Sent: 31 October 2018 11:01
To: Stuart Corbey
Subject: RE: BR/198/18/HH & BR/216/18/L - Milford Cottage

The proposal is for the demolition of an existing outbuilding, and the erection of a two storey extension.

Milford Cottage is attached to the Grade II listed building, 10 The Steyne, and therefore is itself a listed structure. Originally a single building with slate roof and rendered walls, the house in question is now in separate ownership, and forms a small house which is accessed from Market

Proposed street-scene

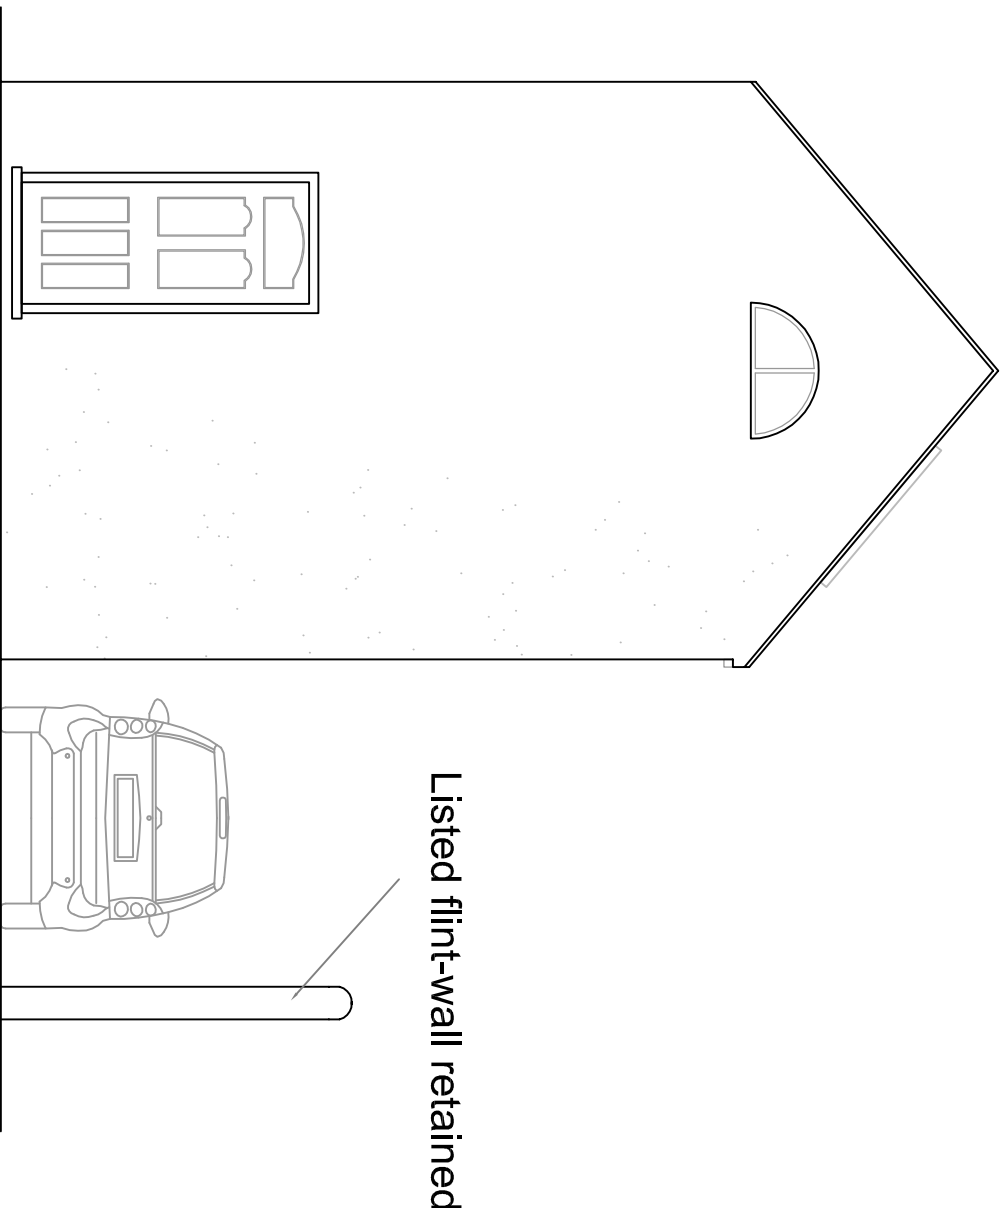
Looking at the proposed elevations, it looks as if the proposal results in the loss of an original/older sash windows. Such a proposal cannot be supported. The use of French windows complicates the elevation and is in contrast with the simple nature of the building. The proposed east elevation contains a single door and small first floor window which does not make a positive impact upon the street-scene.

Scale 1:50		Applicant: Angela Taylor Address: Milford Cottage Bognor Regis PO21 1TD	
Project: Two-storey extension		Revision date: PLA002	
Scale: 1:50 @ A1		Date: 11/07/2018	
Title: Proposed floor plan and elevations		Plan No: PLA002

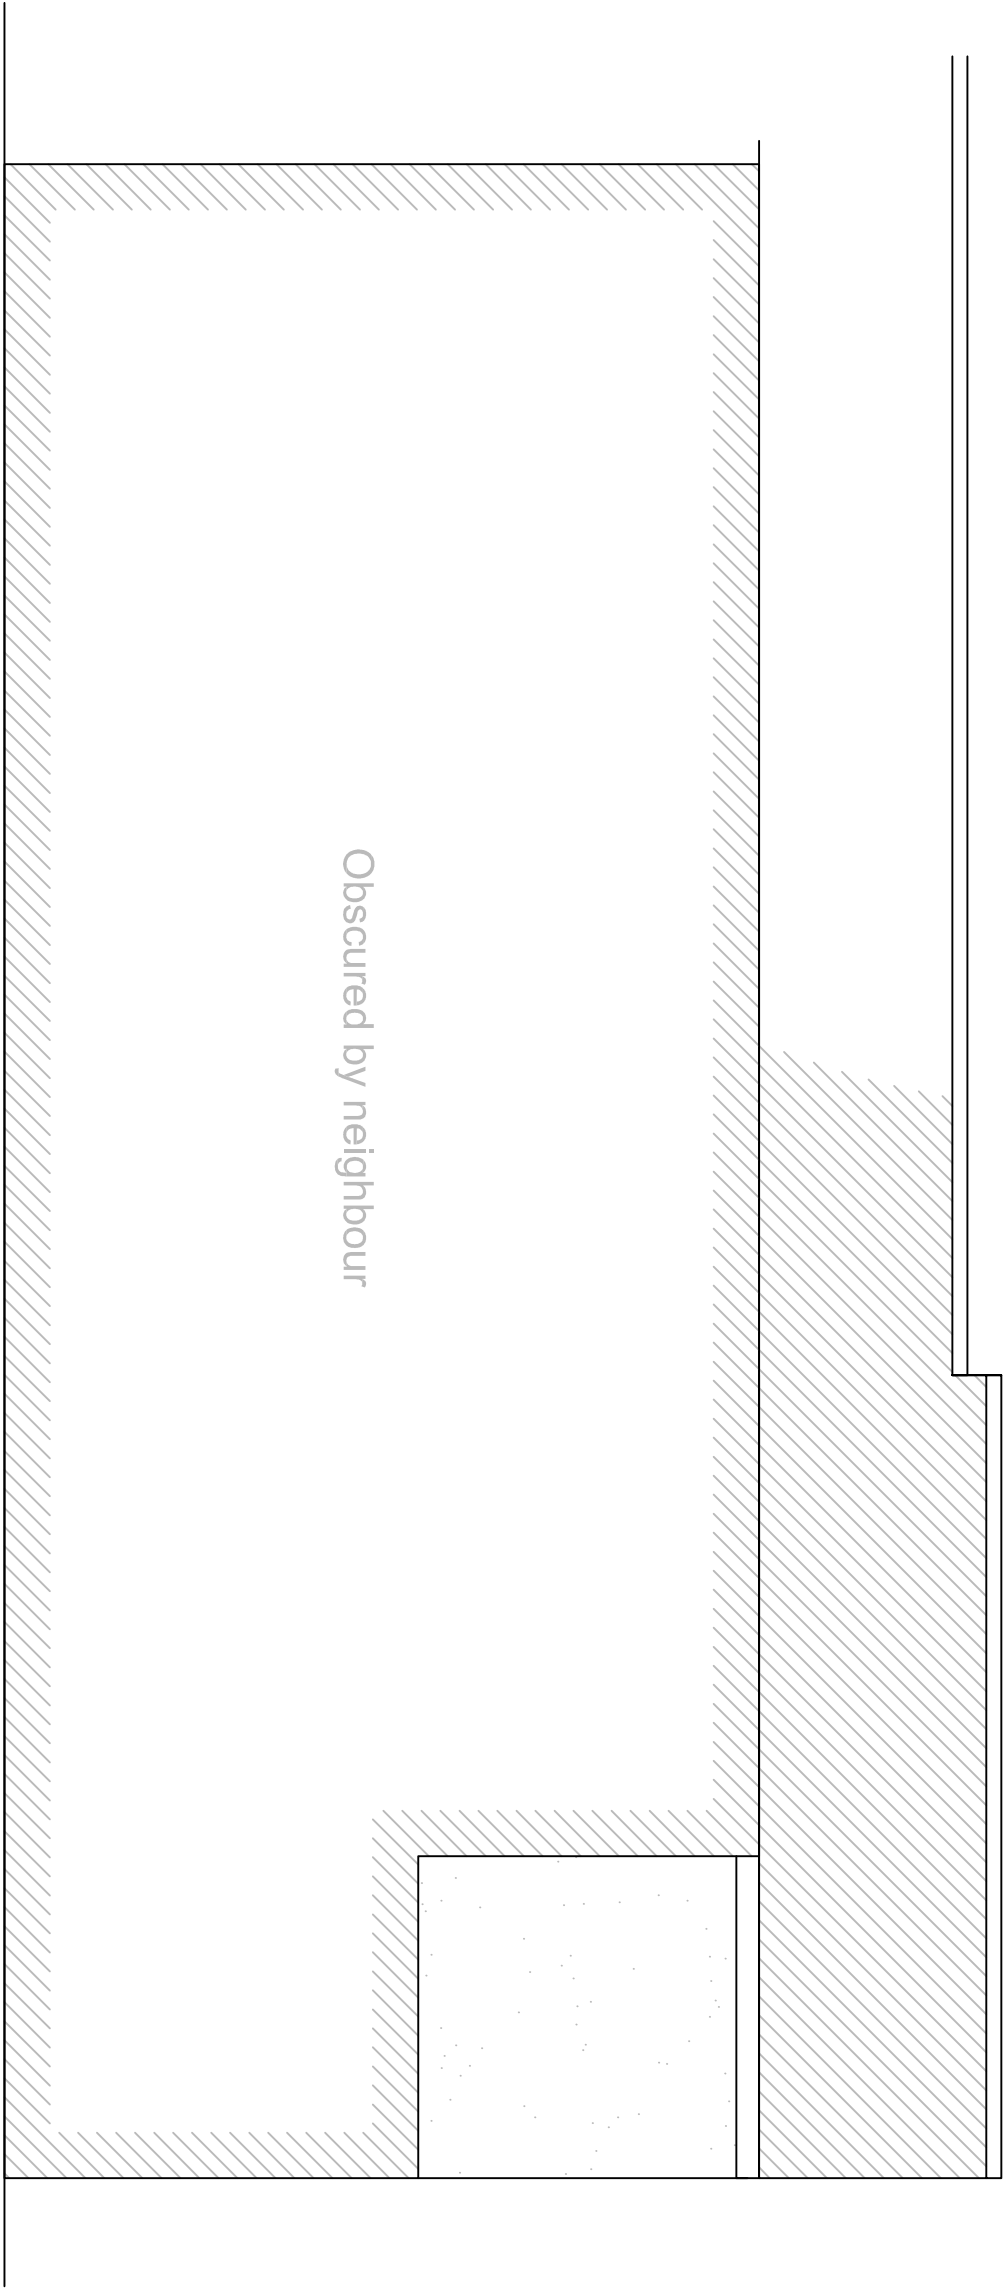
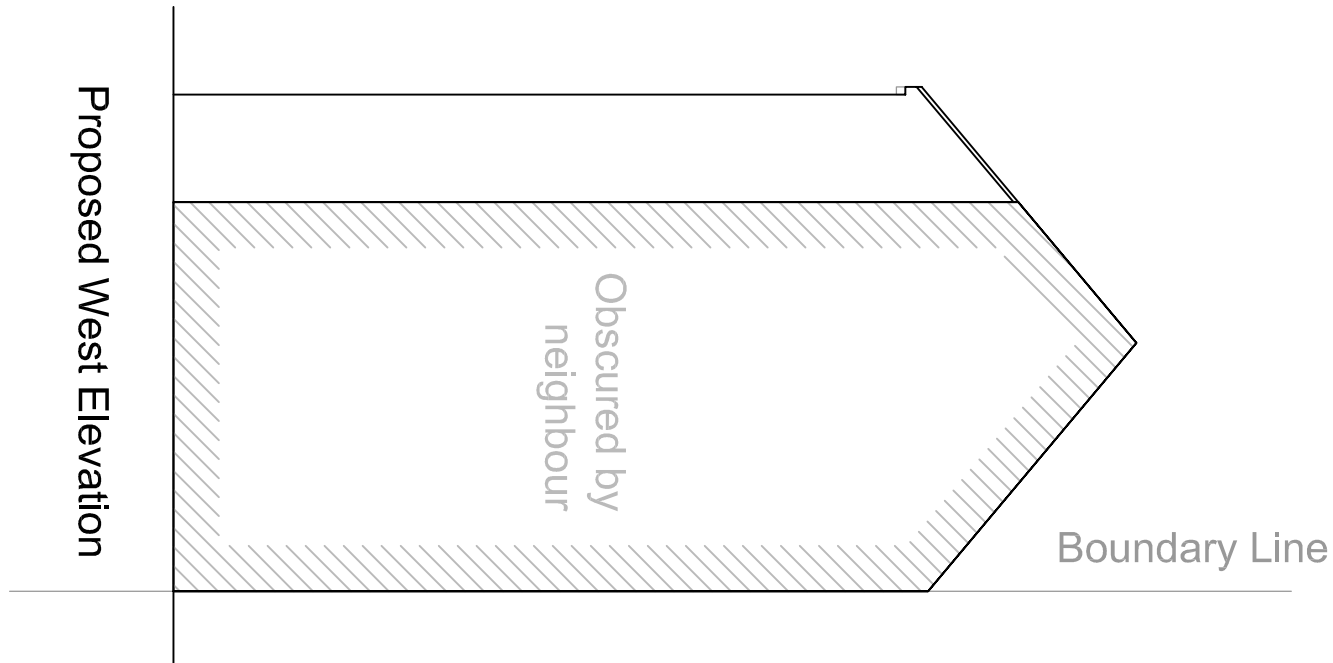
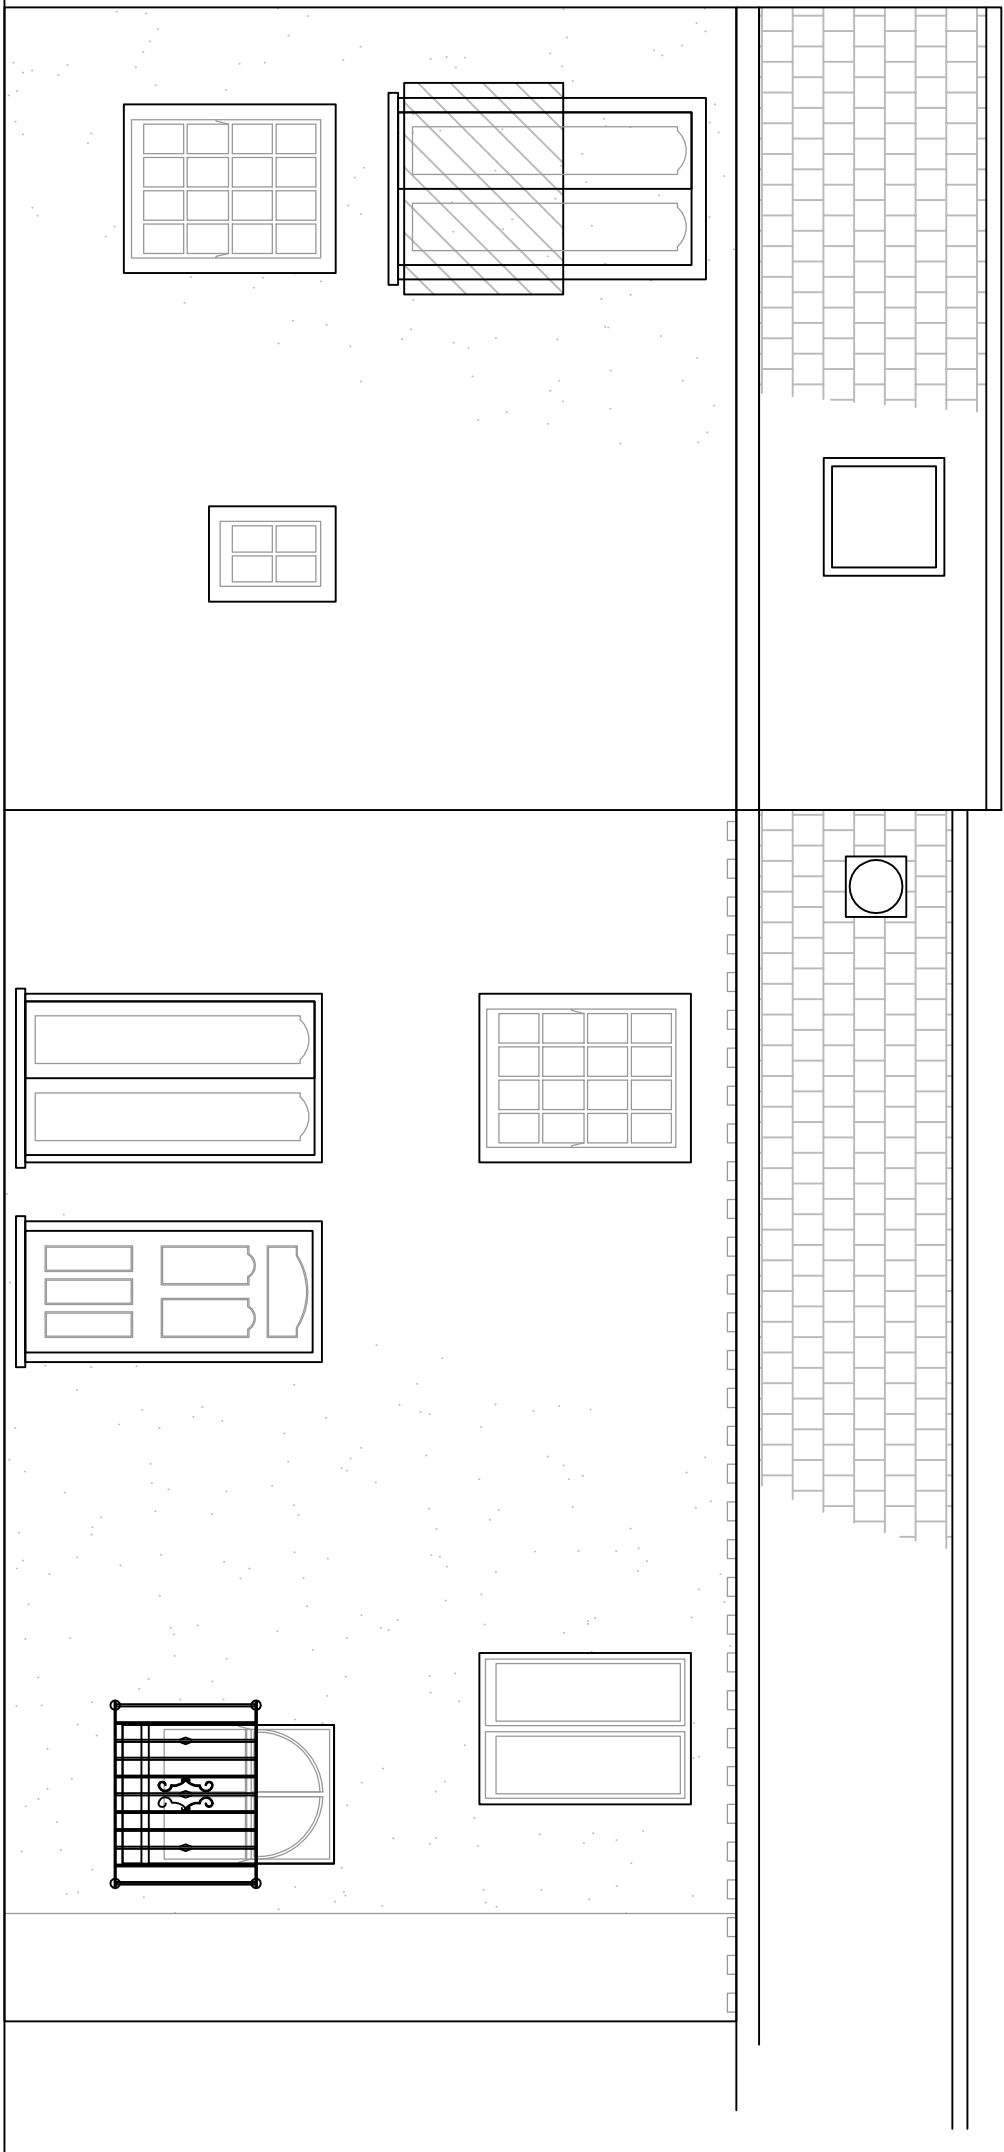
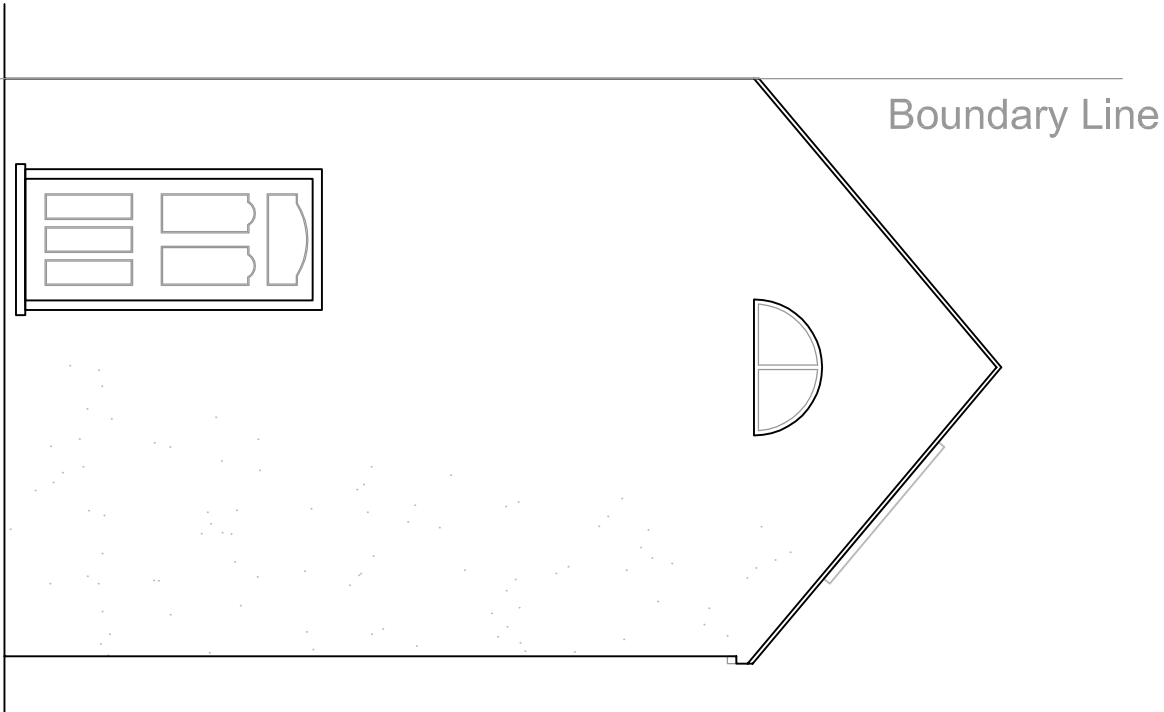
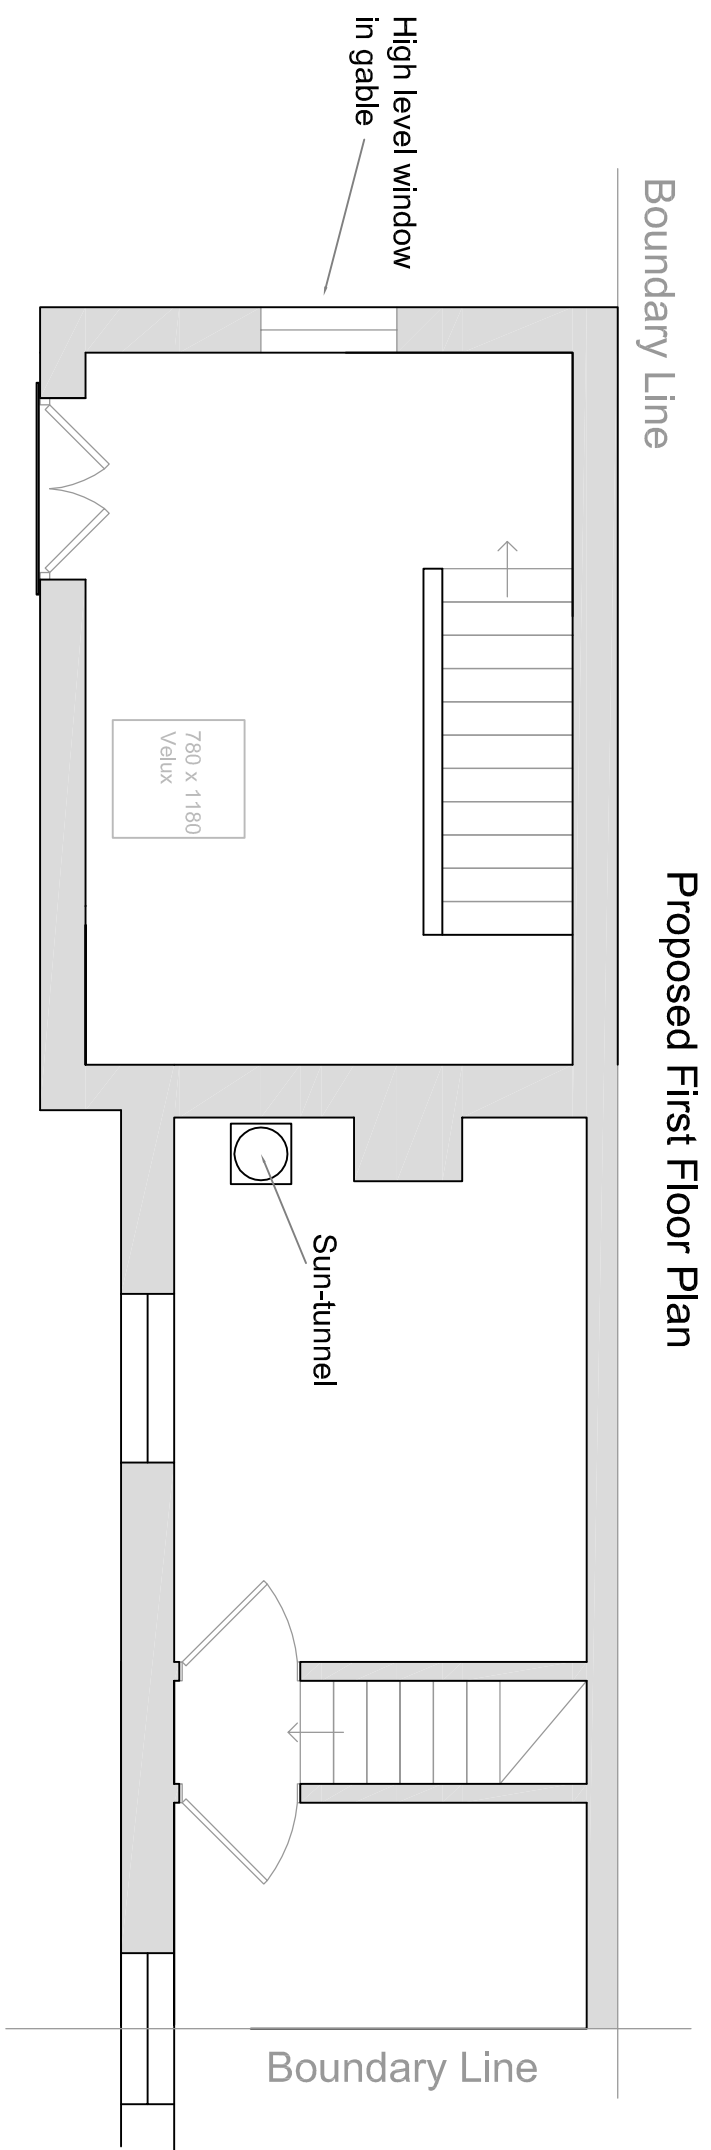
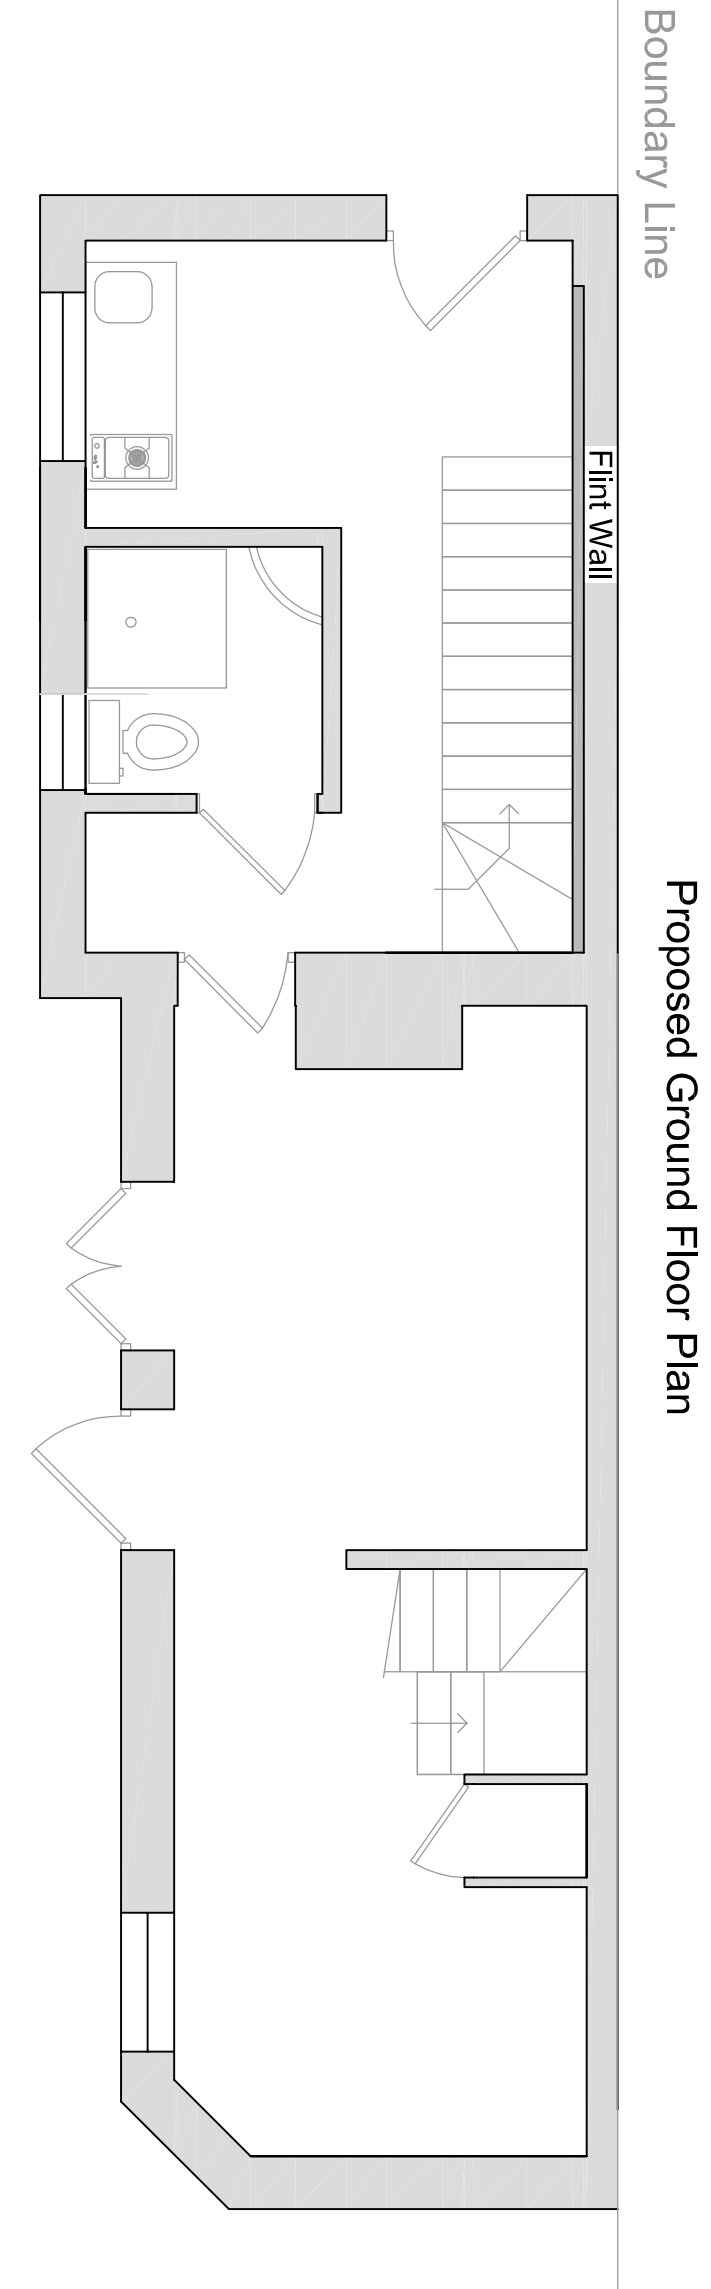
The proposed two storey extension, on the other hand, is considered problematic and cannot be supported in its current form. The extension is considered to be substantial in nature and is wider than the host dwelling. It therefore cannot be considered to be subservient to the host dwelling.

In addition, it seems to accommodate a significant amount of the curtilage with very limited uses; a bedroom, shower room and a large area of hallway/corridor space.
